Subject: VA-24-00001 Burke - Notice of Application

TO: All Staff
FROM: Public Works Plan Review Team
DATE: March 19th, 2024
SUBJECT: Public Works Comments: VA-24-00001 Burke

SITE PLAN
#22055

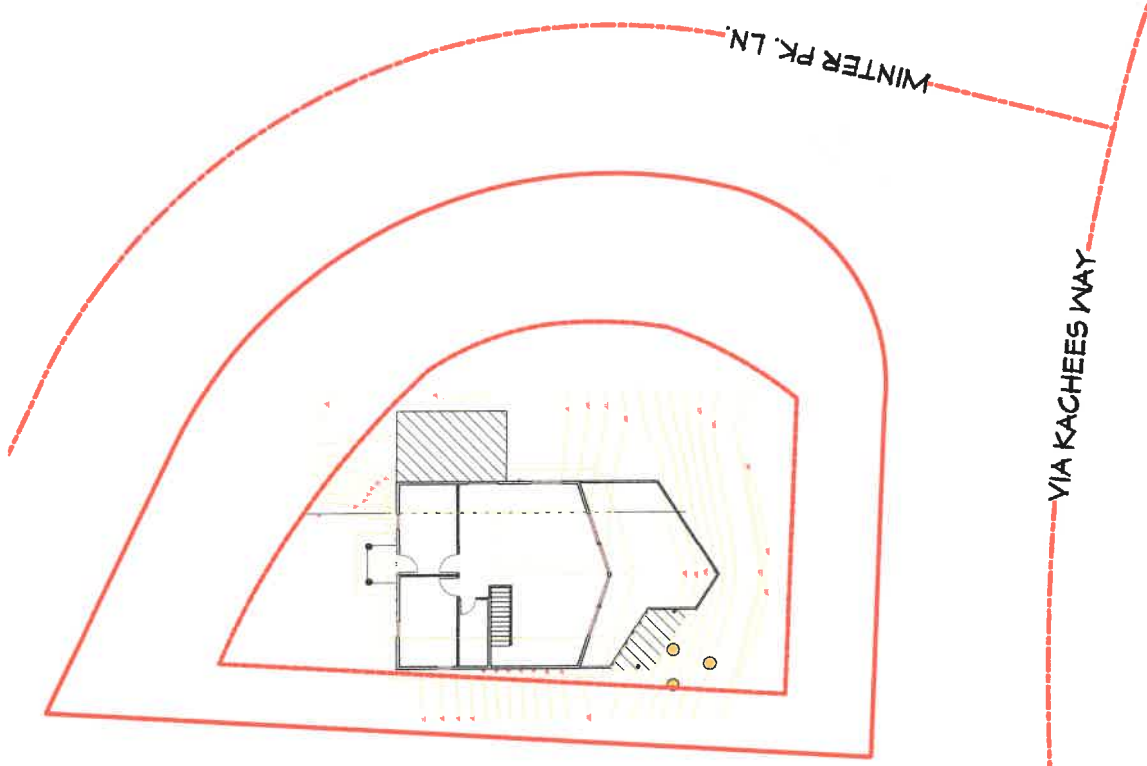
ACCESS	Applicant has an approved access permit is on file with Public Works (2004-650). No additional access comments.
ENGINEERING	Public Works is concerned that sight distance may be compromised with the additional overhang based on the site plan. The site plan does not provide enough information for this to be determined. Applicants should submit a site plan showing the edge of asphalt on Winter Park Ln and Via Kachess Rd, as well as the proposed improvement. Public Works would also accept a stamped plan from a licensed engineer verifying site distances, as described in Exhibit 1260-1 of the WSDOT Design Manual, are met.
SURVEY	The provided Site plans do not address how the boundaries (and subsequent setback lines) were determined. Based upon the road monuments located by the county in 2019, it appears that the existing house may already actually fall just 10 feet from the boundary line. Adding the proposed overhang would be a zero setback rather than a 15 foot setback. County survey strongly recommends a private land surveyor prepare a site plan prior to approval OR a private land surveyor is utilized during construction to ensure that revised setbacks are not encroached. (JT)
